A1 in Northumberland: Morpeth to Ellingham

Scheme Number: TR010059

Summary of Proposed Changes to Application

Regulation Reference:	Infrastructure Planning (Examination Procedure) Rules 2010
Planning Inspectorate Scheme Reference	TR010059
Document Reference	TR010059/7.5
Author:	A1 in Northumberland: Morpeth to Ellingham Project Team, Highways England

Key

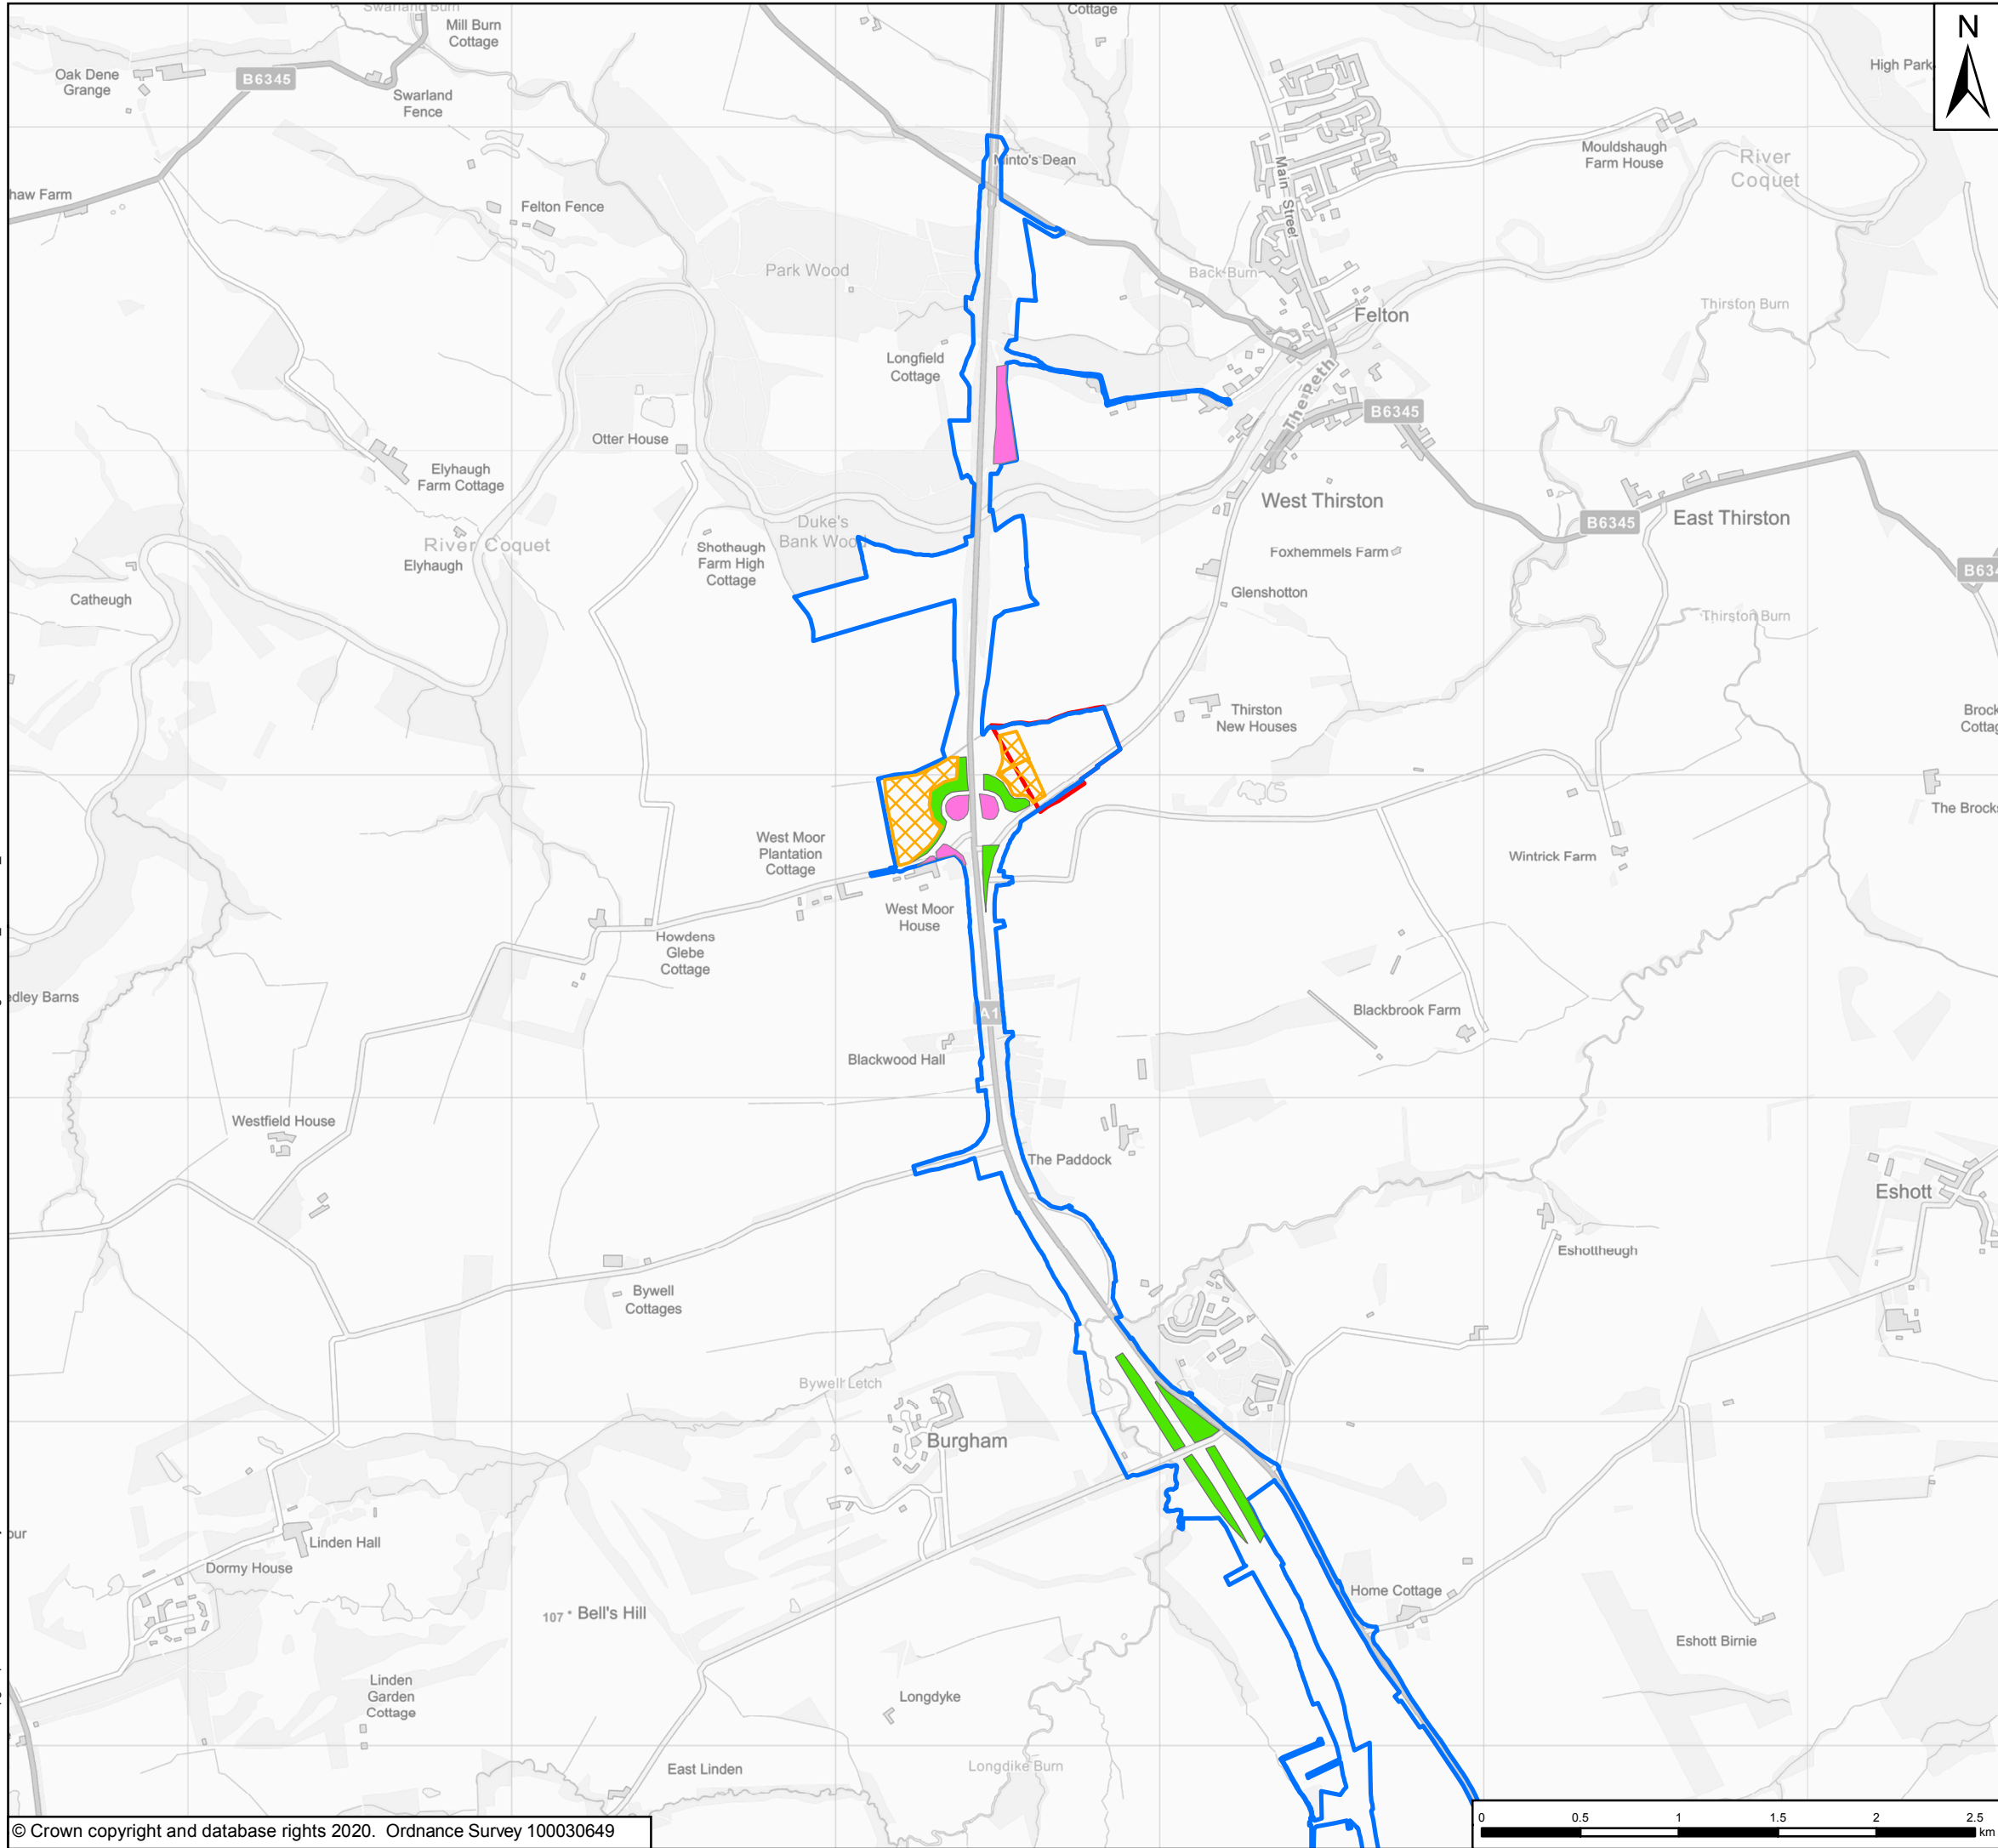
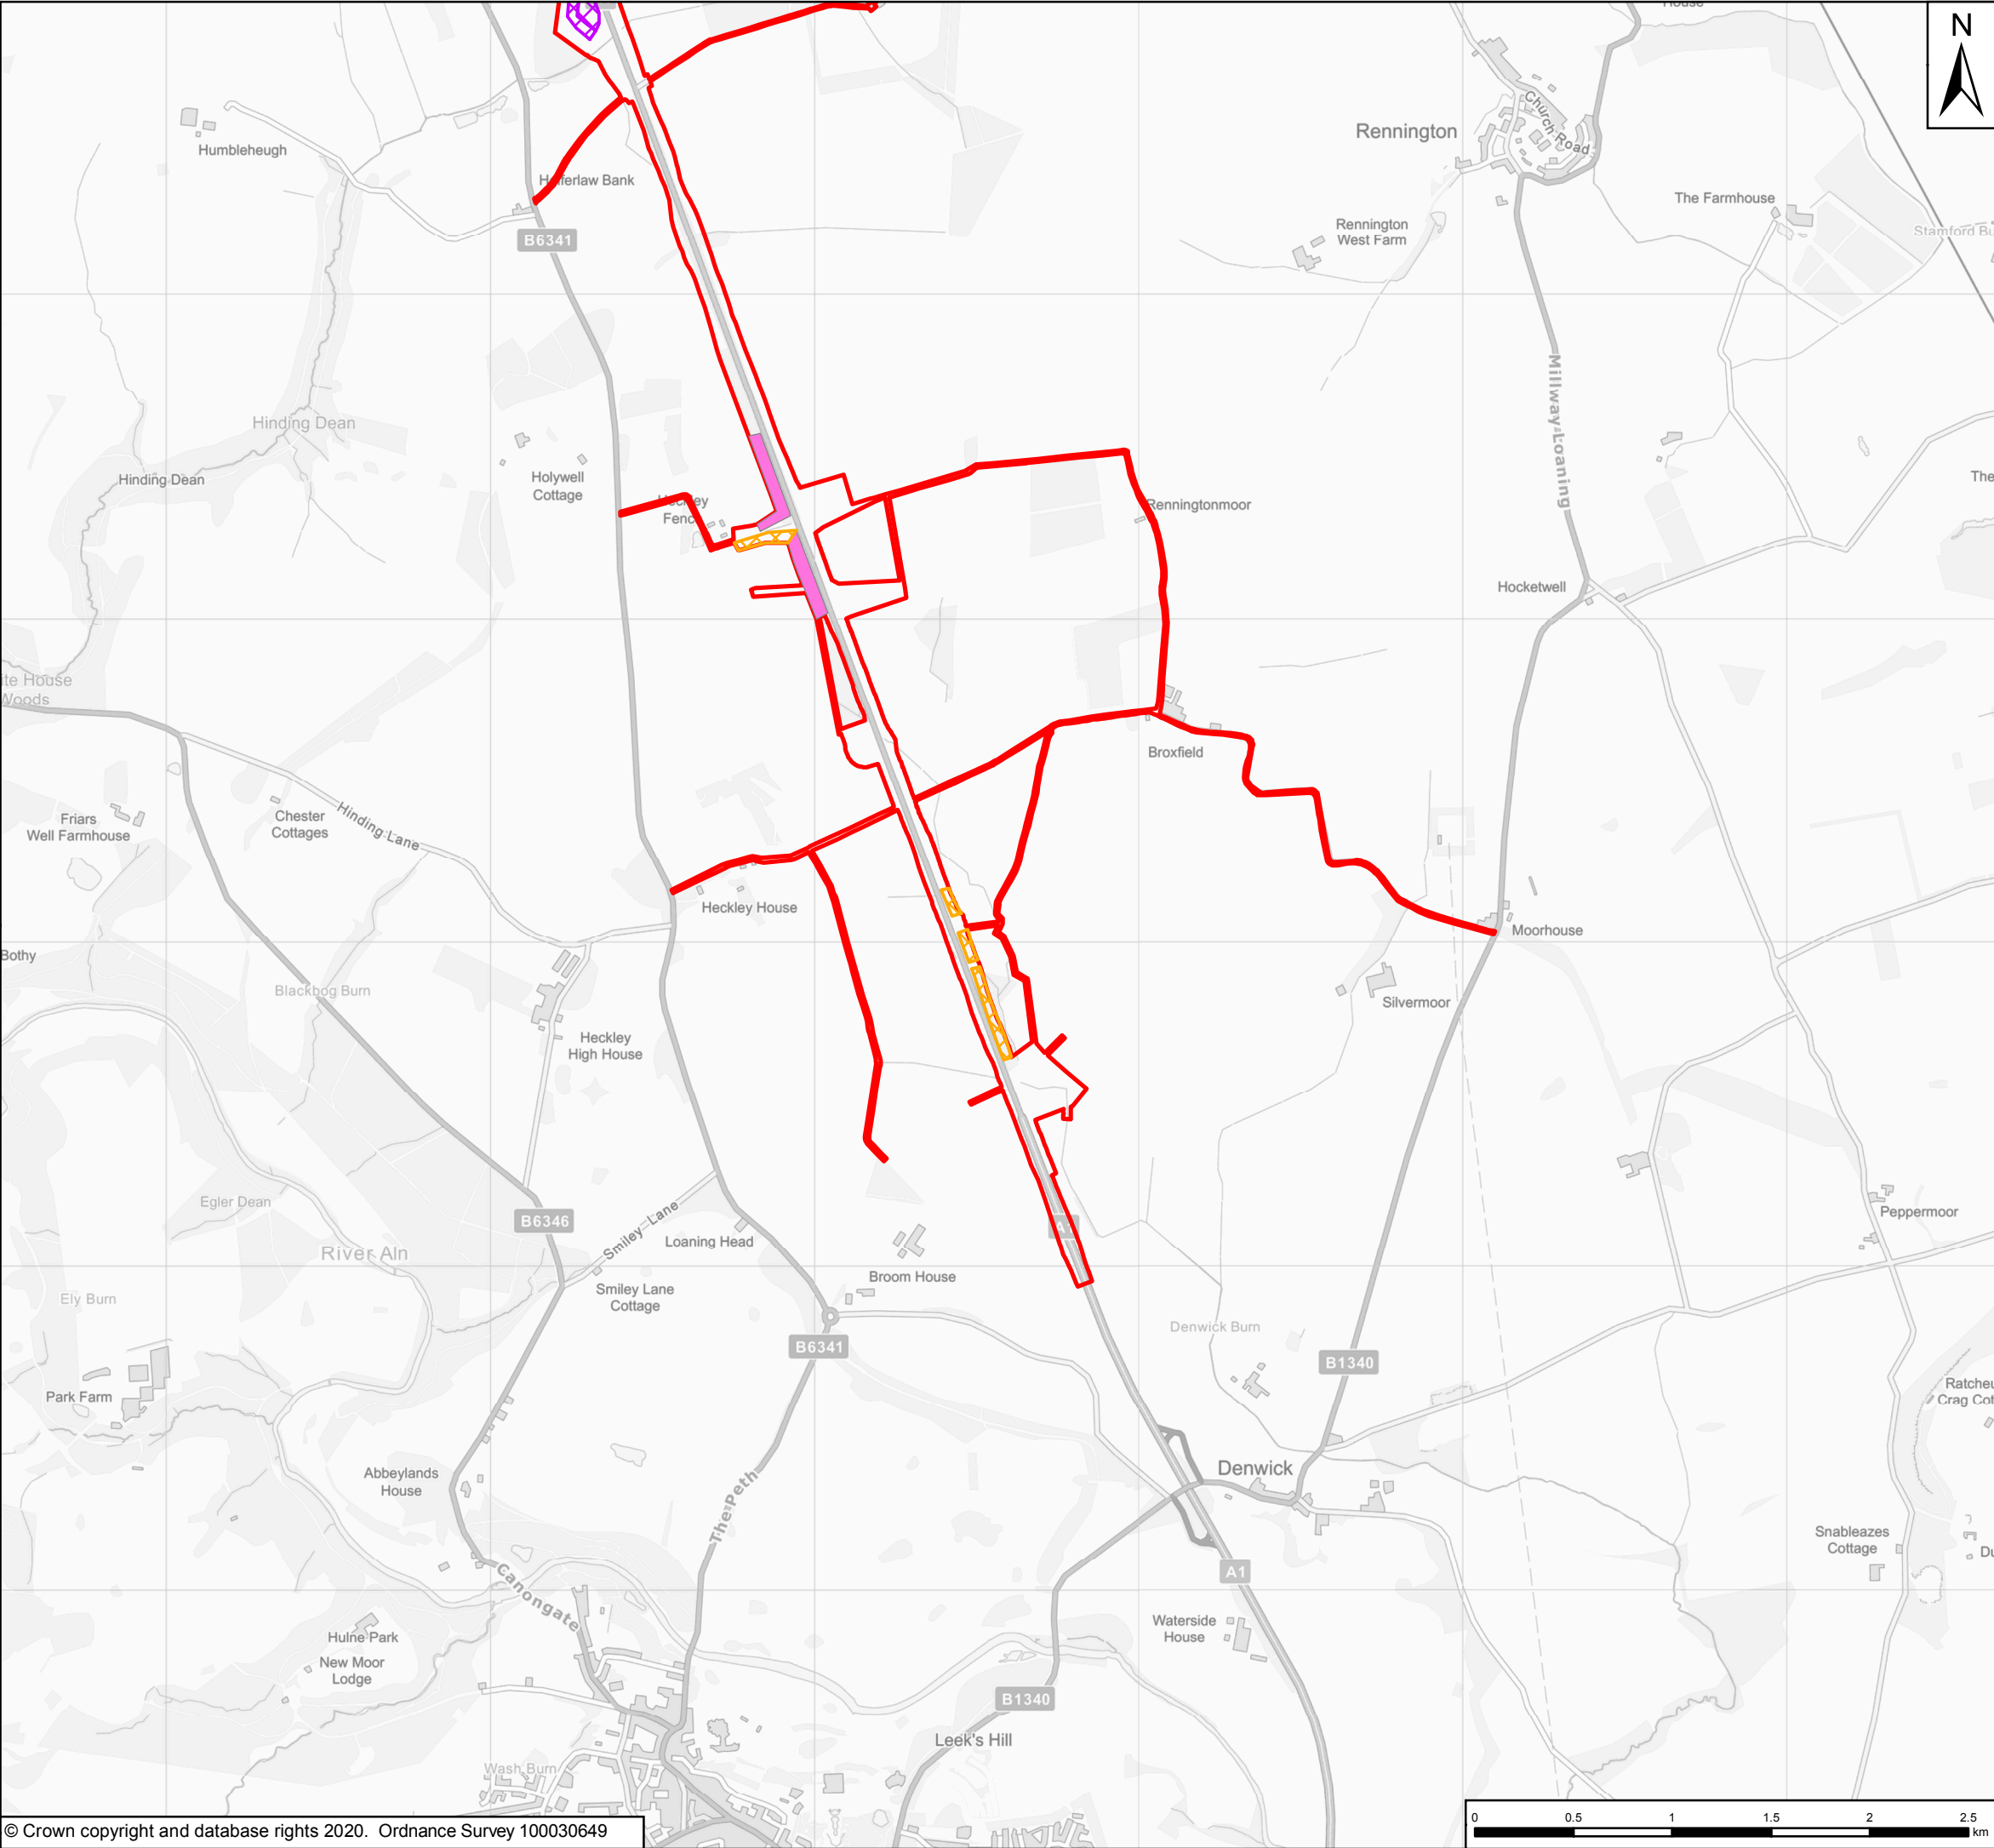
- 2.1.1 The Applicant proposes to maximise the re-use of materials (via excavation, deposition and temporary storage), within the existing Scheme extents. A recent review of the earthworks strategy has identified an opportunity to reduce earthwork movement and as a result greater flexibility in temporary and permanent storage of Site won material is required to achieve this. The indicative earthworks areas are shown in the figure in the **Indicative Earthwork Change Locations** figure in **Appendix A**.

- 2.1.2 To balance materials across both Parts A and B, the following methods are proposed:
- Utilising borrow pits to exchange and win additional material suitable for construction.

- Maximising use of soil bunds already specified within the **Figure 7.8: Landscape Mitigation Masterplan** for Part A [APP-095], **Figure 7.10 Landscape Mitigation Masterplan** for Part B [APP-144] and **Figure 7.14: Landscape Mitigation Masterplan including Assessment Parameter 3** for Part B [APP-148], for disposal of excess site material, in Part A.

- Maximising of fill within slopes, already specified within **Figure 7.8: Landscape Mitigation Masterplan** for Part A [APP-095] and **Figure 7.10 Landscape Mitigation Masterplan** for Part B [APP-144] and **Figure 7.14: Landscape Mitigation Masterplan including Assessment Parameter 3** for Part B [APP-148], for re-use of site material, in Part A.

- Creation of new soil bunds within Part B to maximise re-use of excess site material.
 - Maximising of slopes for re-use of excess site material, in Part B.

- Laying down additional material increasing some localised ground levels.
 - Raising levels of junction “bowls” (level or rounded rather than dished).

- Creating new, temporary soil storage areas within both Part A and Part B.
- 2.1.3 These changes are an alteration to Parameters 4 and 5 for Part A, as set out in **Chapter 2: The Scheme** of the ES [APP-037]. There would also be additional temporary and permanent earthworks that require assessment for Part A and Part B. Therefore, it is appropriate to ensure that the environmental information before the Examination addresses the prospect of altered impacts This is addressed by sensitivity testing as described at **paragraph 2.1.6** below.
